West Oxfordshire District Council

Response to Botley West Solar Farm Statutory Consultation

February 2024

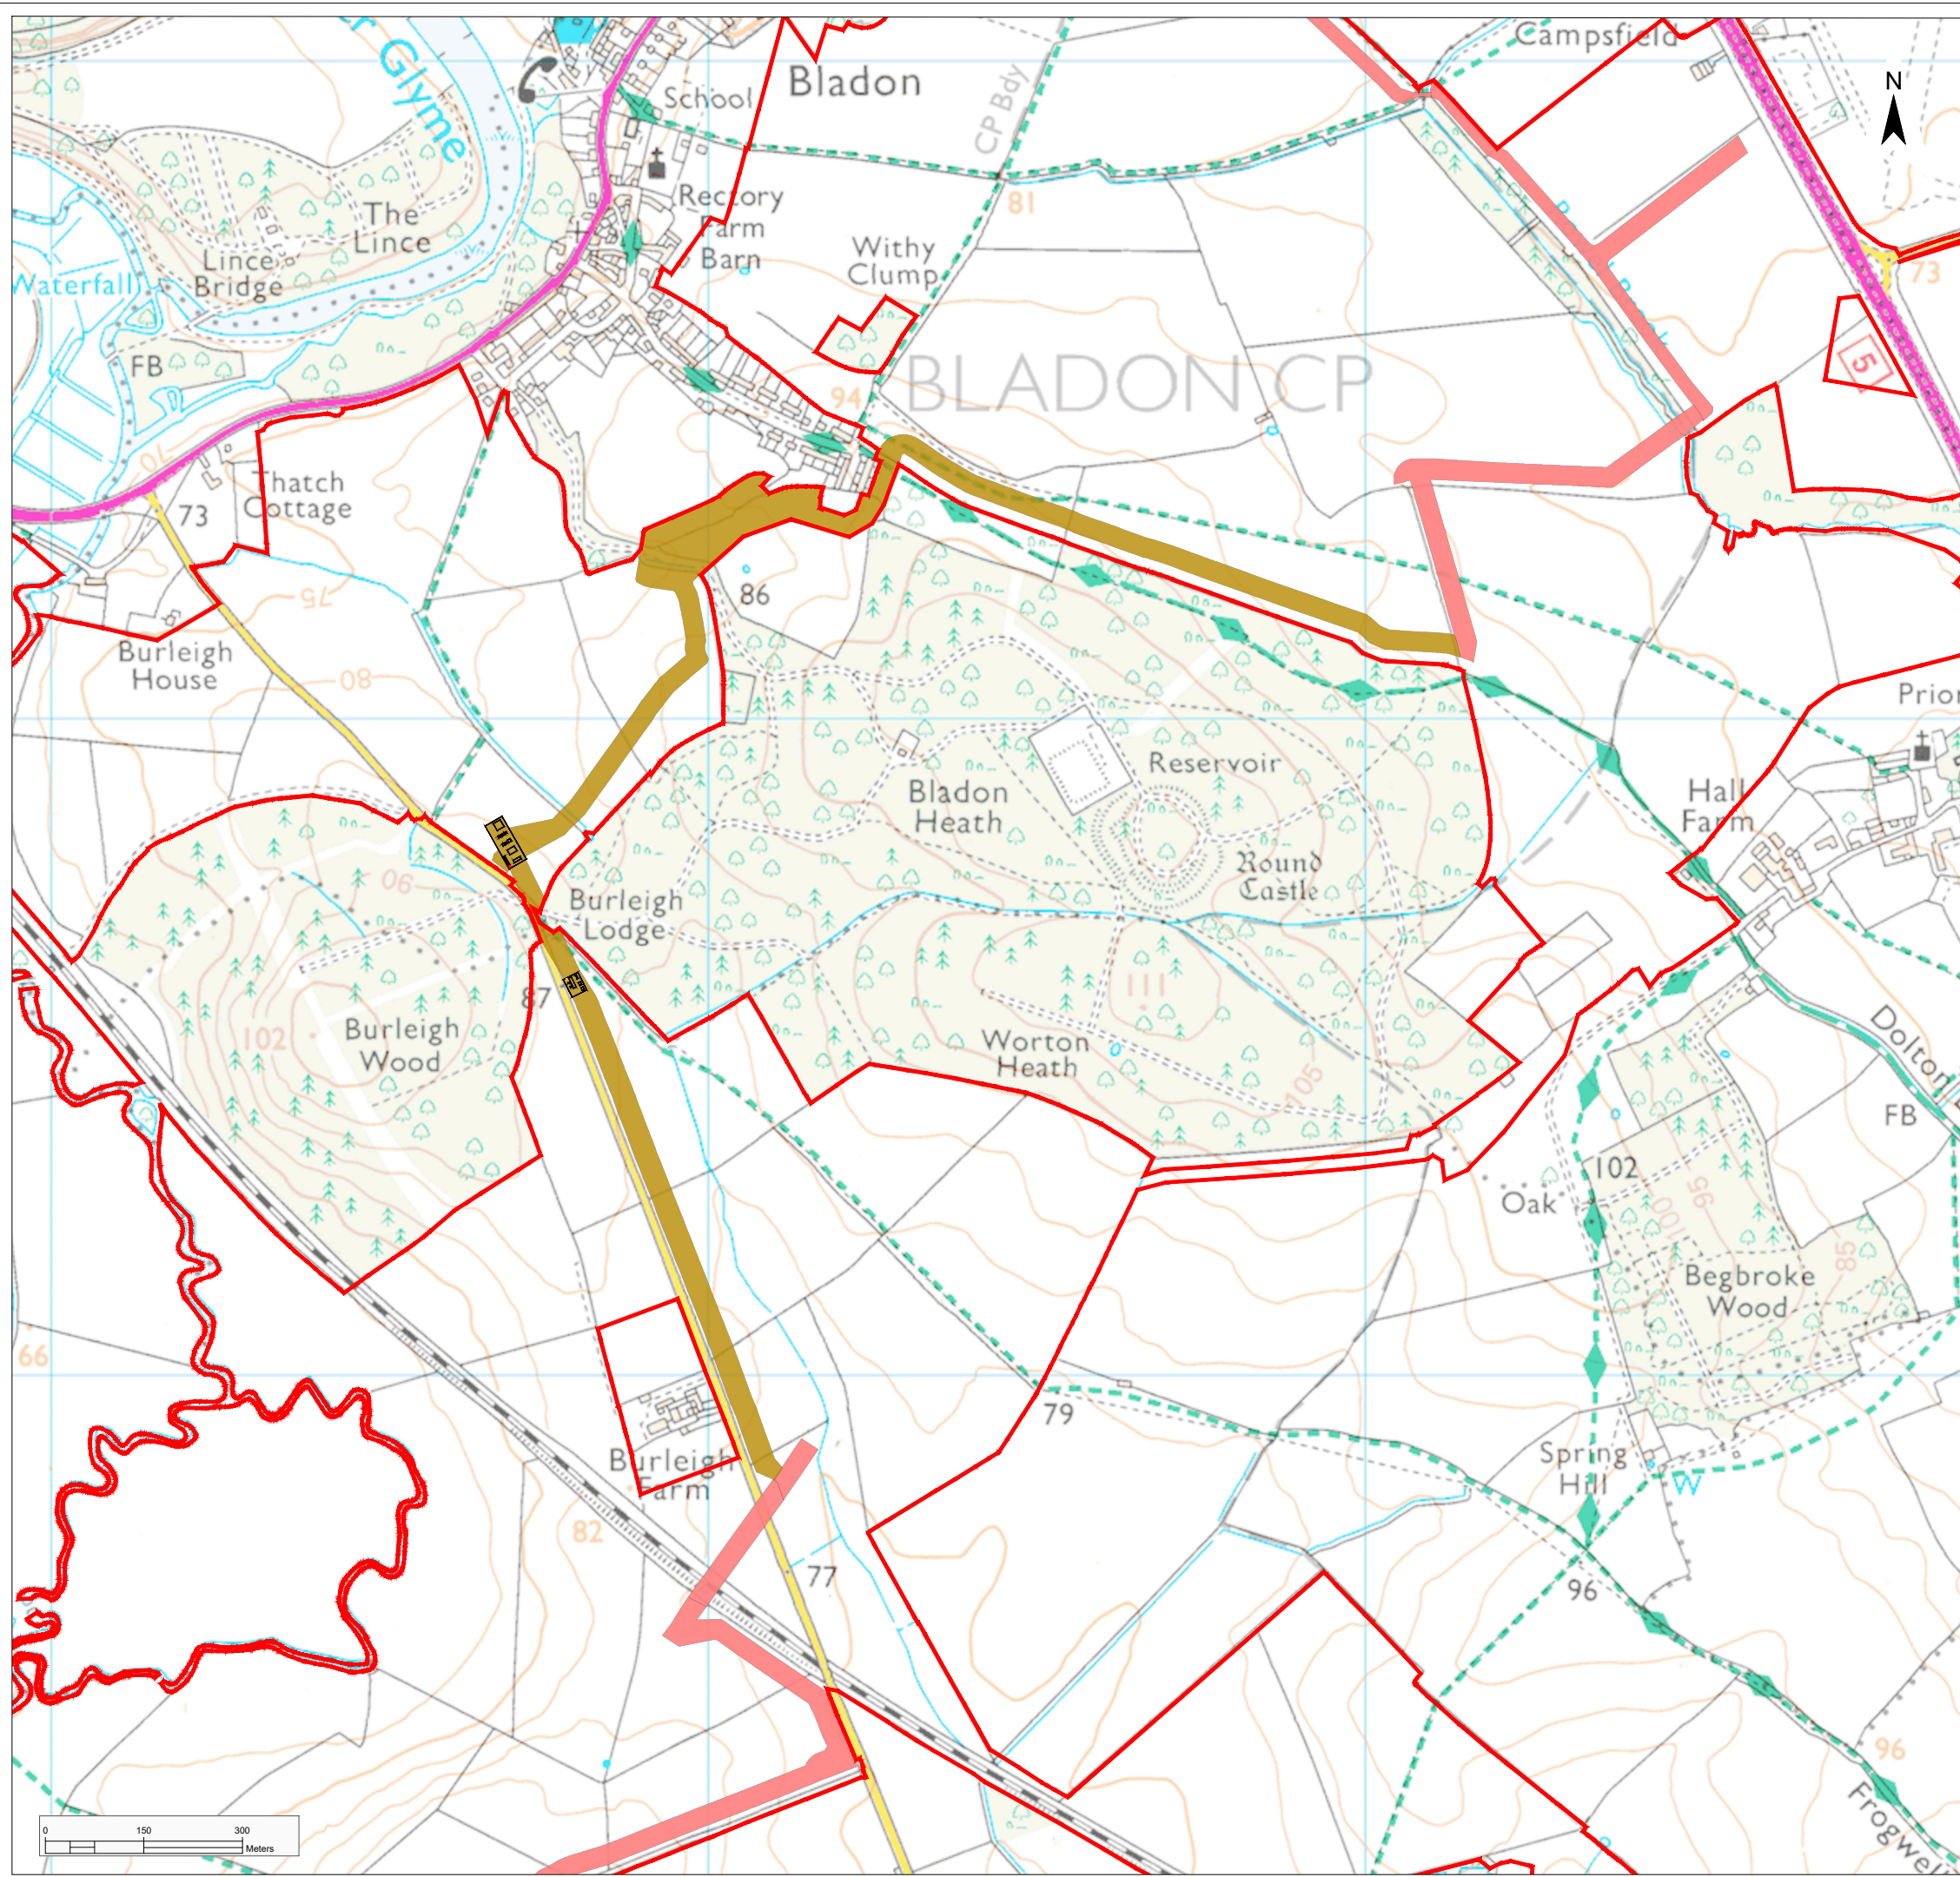
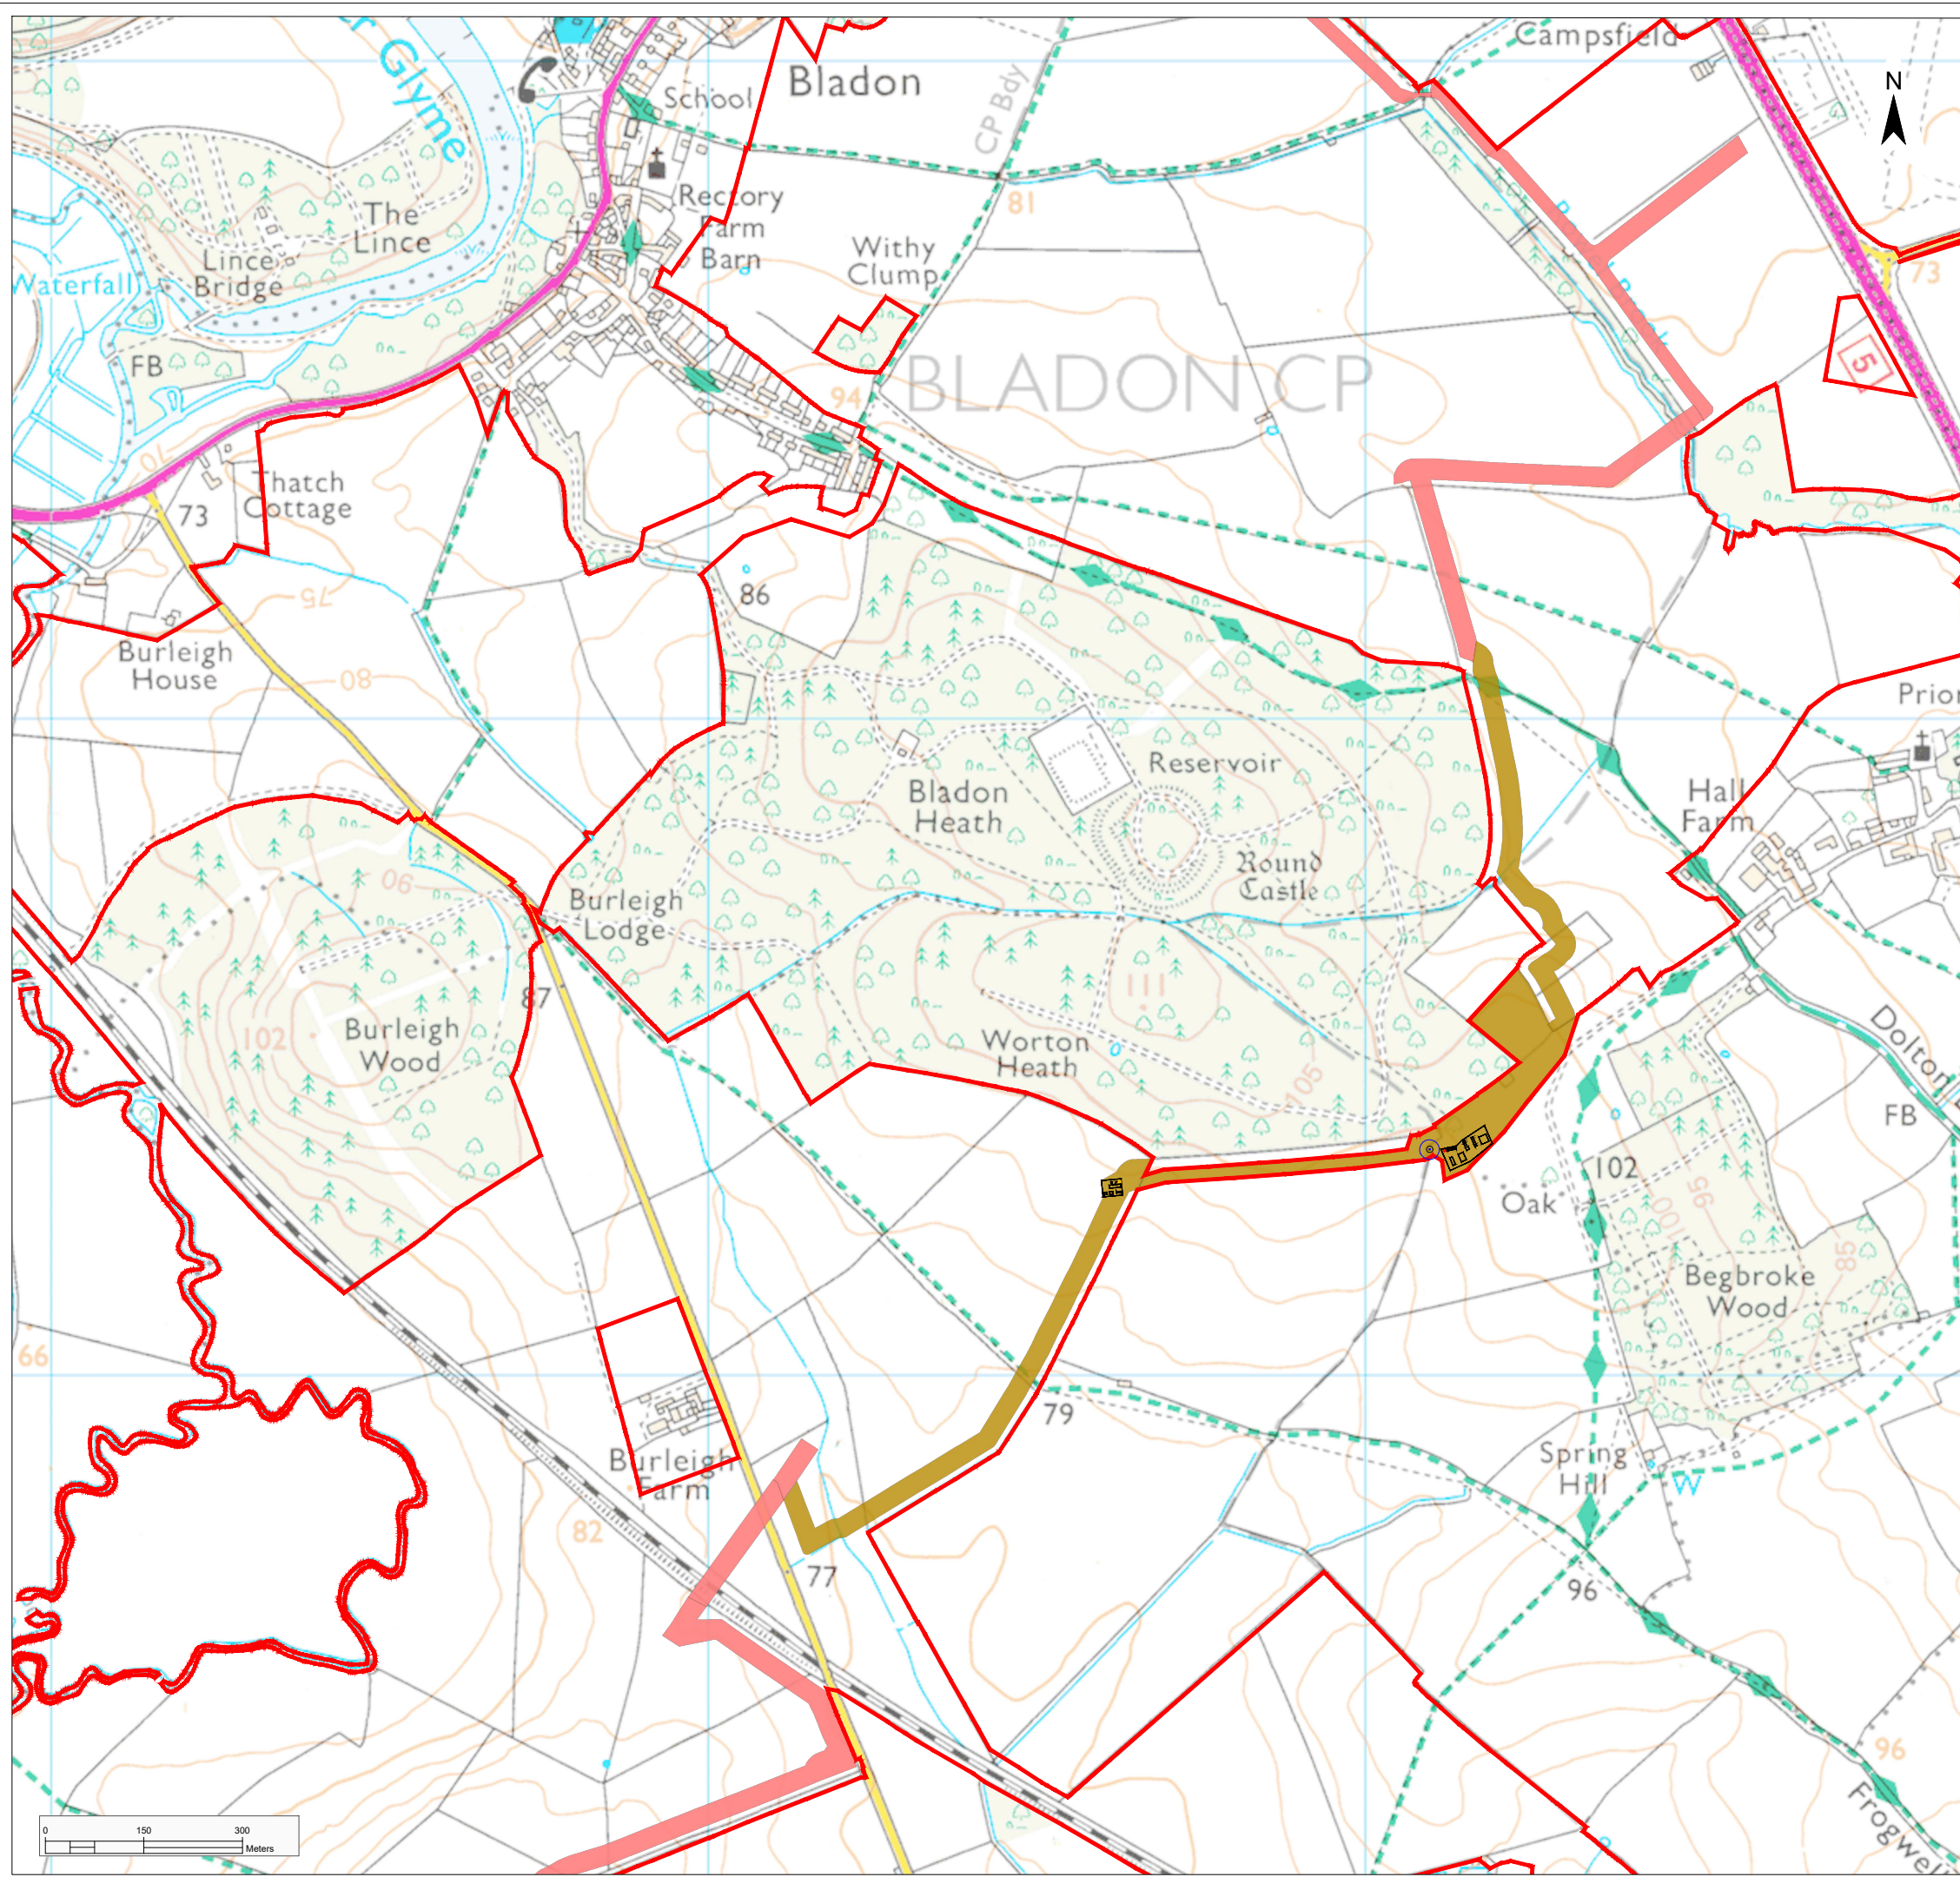
- 4.20 **WODC suggest that removal of development areas from the visually exposed and prominent valley sides to the west of Lower Road and valley sides of the River Evenlode could minimise negative impacts of the proposal. This will reduce potential for negative landscape character impacts by restricting development in visually prominent and exposed locations and minimise impacts on the setting of Church Hanborough Conservation Area.**

- 4.21 **WODC also suggest that development be restricted from land to the north of Cassington. Although the masterplan indicates that development would be set back from the edge of the settlement in this location, land rises steeply to the north of the settlement making any development in this location prominent and visually exposed. This area is also within the Green Belt, which performs particularly well in this location in terms of protecting the historic character of settlements and safeguarding the countryside from encroachment.**

- 4.22 **It is noted from the masterplan that there is a proposed buffer zone to the south of Bladon to mitigate against potential landscape and visual impacts. There are a number of key sensitivities in this location including proximity of residential properties, proximity to the Bladon Conservation Area and the setting of the Blenheim World Heritage Site. WODC consider that the proposed buffer area should be substantially increased to minimise impacts on sensitive receptors in this location.**

- 4.23 **Proposed buffers adjacent to Ancient Woodlands and Public Rights of Way should be increased in this area to reduce impacts on the PROW network and provide opportunities for further woodland creation. The applicant is proposing a 15m buffer around Ancient Woodlands in accordance with Natural England guidance. WODC understand that proposed buffer distances are designed to protect the root structure of trees rather than protecting the visual importance and sensitivity in the landscape of those woodlands and presenting real enhancement opportunities. Opportunities should be sought to increase woodland cover in the area where possible. There are two public rights of way along the eastern side of Bladon Heath. Stepping development away from these would mitigate the impacts on sensitive users of the public rights of way network**
